Recommendation Report for Planning Permission for Works or Extension to a Dwelling

REF NO: WA/17/26/HH

LOCATION: Fairview
8 Daffodil Gardens
Arundel Road
Fontwell
BN18 0XQ

PROPOSAL: Proposed garden building for ancillary use.

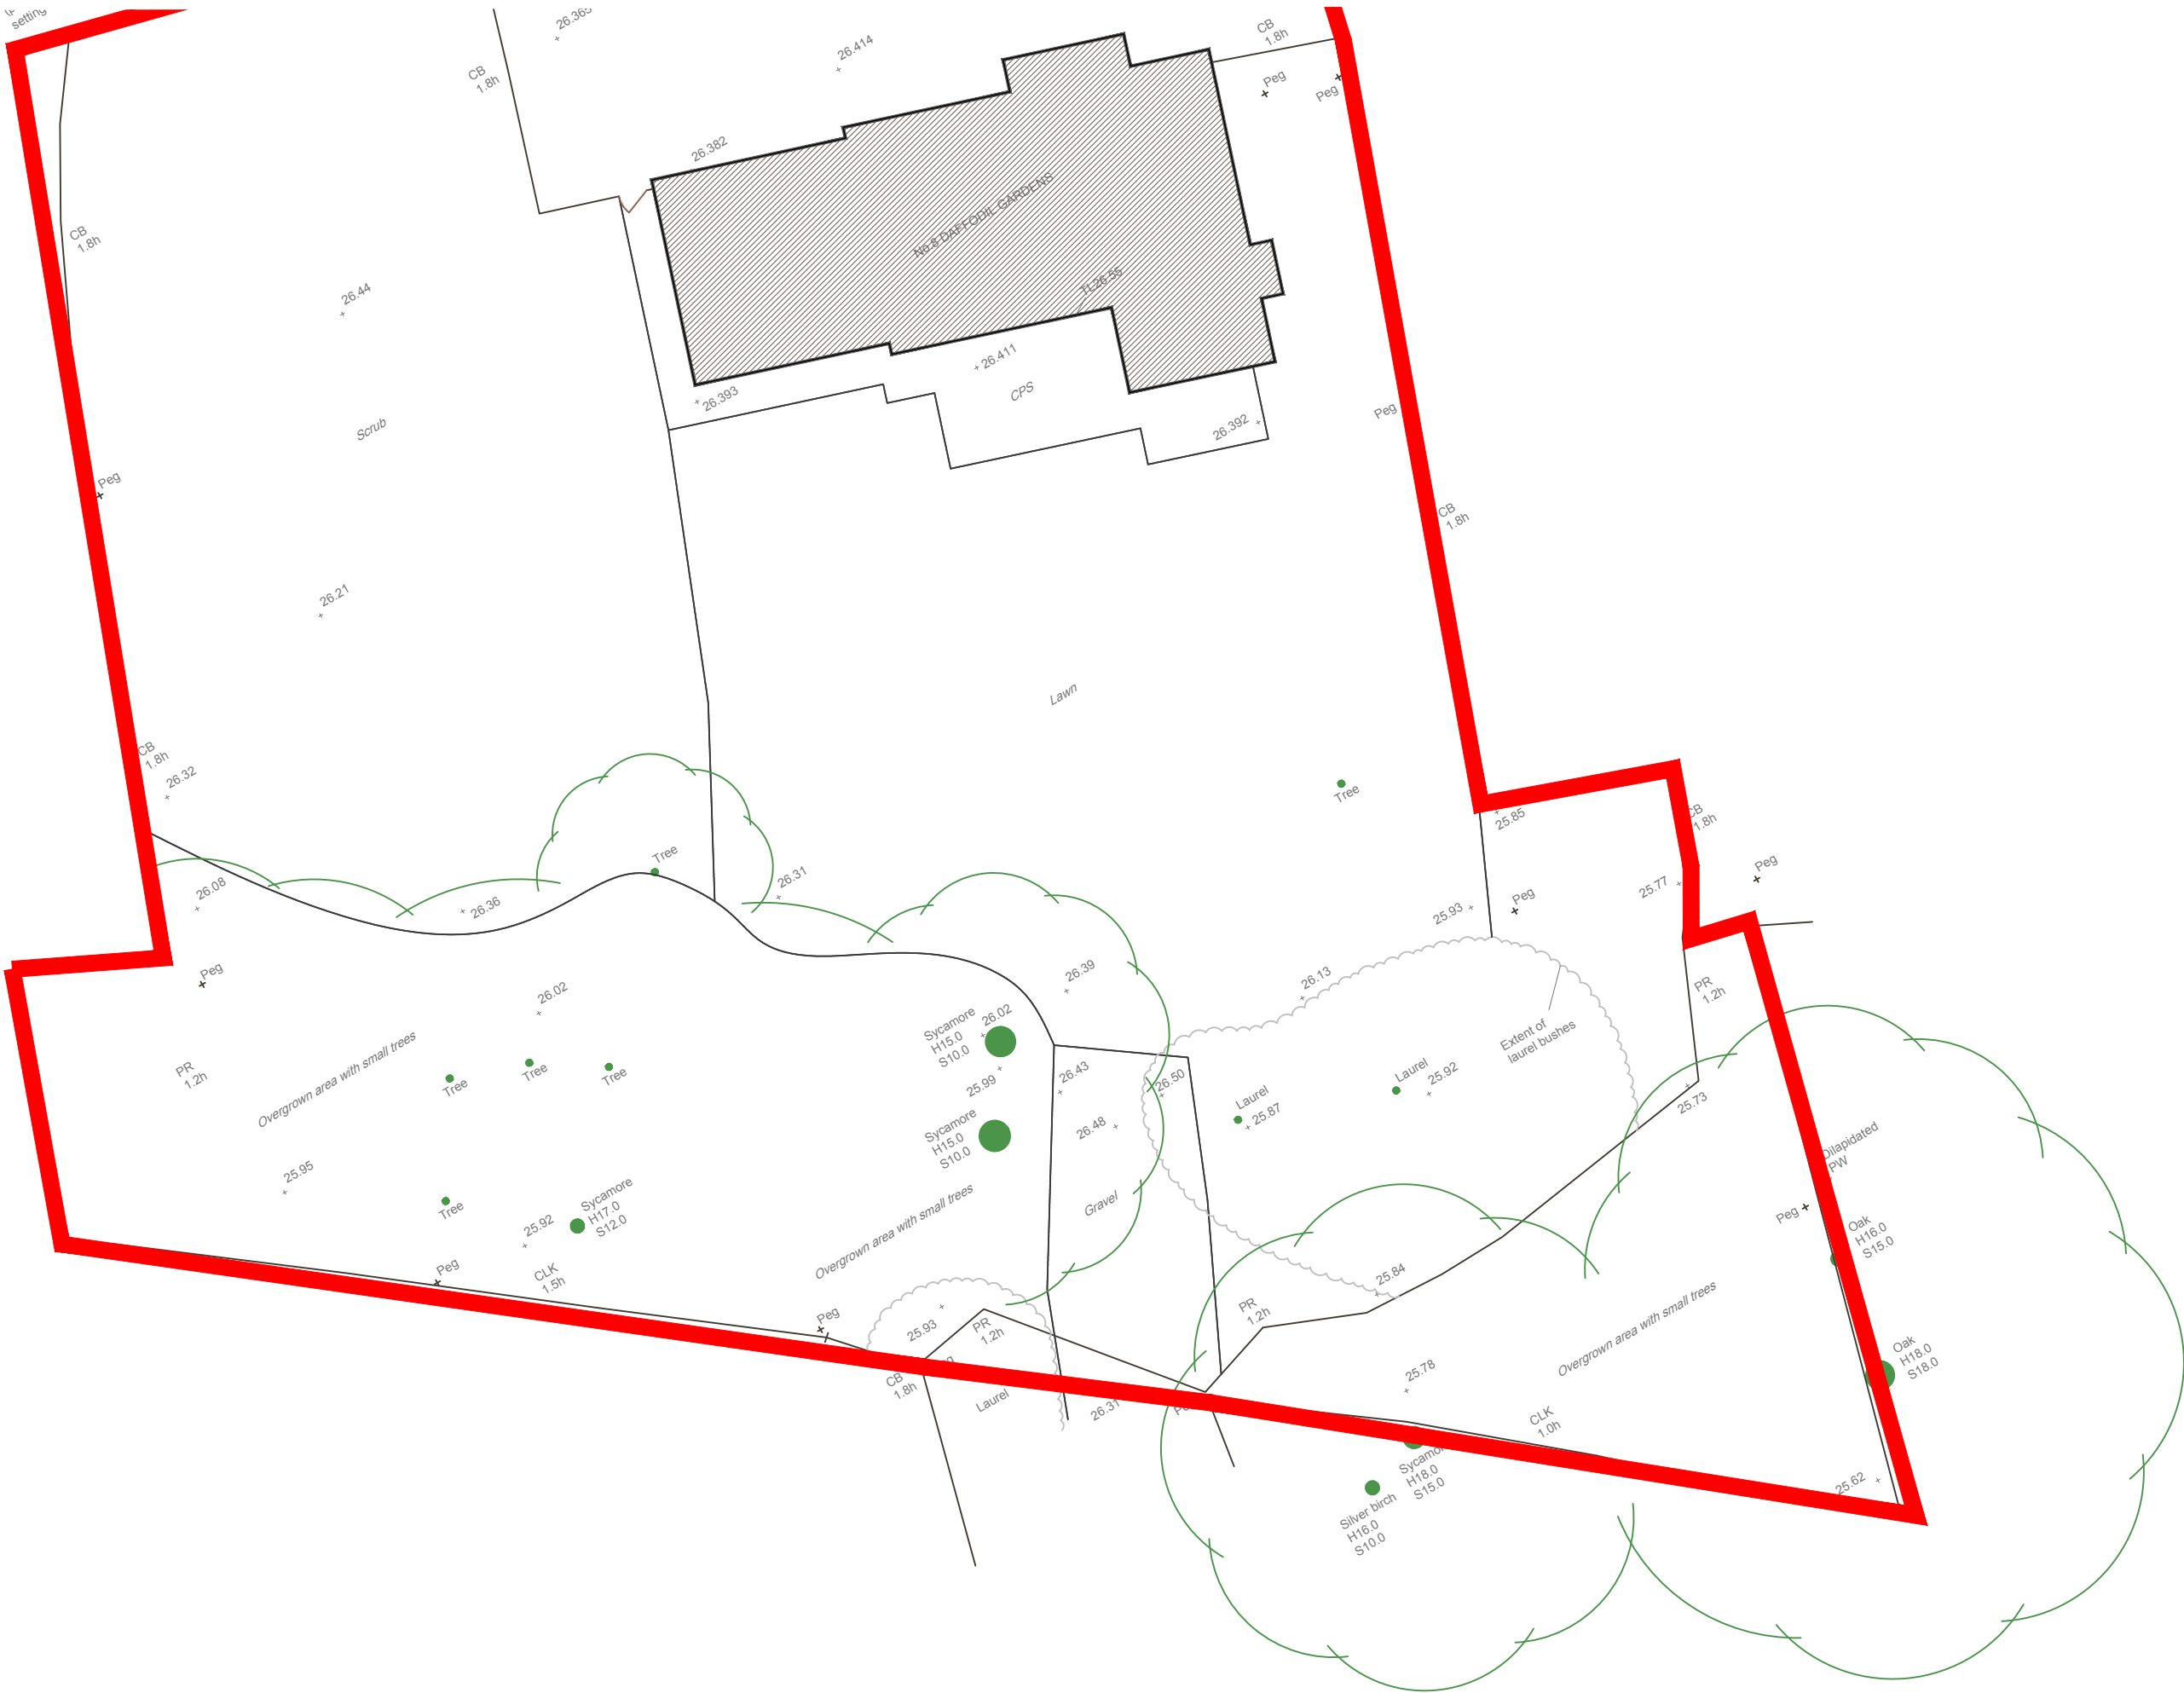
Higher value trees (retention category B) and one subject of a Tree Preservation Order (their ref. T8), are largely grouped in the southeast corner of the plot. This is the proposed location for the garden building.

Crown spread from one protected oak and other retained trees is affecting at present and will develop if left, given their high growth potential. Falling debris and risk associated with branch failure may be low but a single event of high impact on what is a less resilient structure than main dwelling, could dramatically alter the occupier's perception of them and subsequent management intentions. I find the siting of the building somewhat ill-conceived for this reason. It seems optimal to position it due west, beyond the influence of higher value trees.
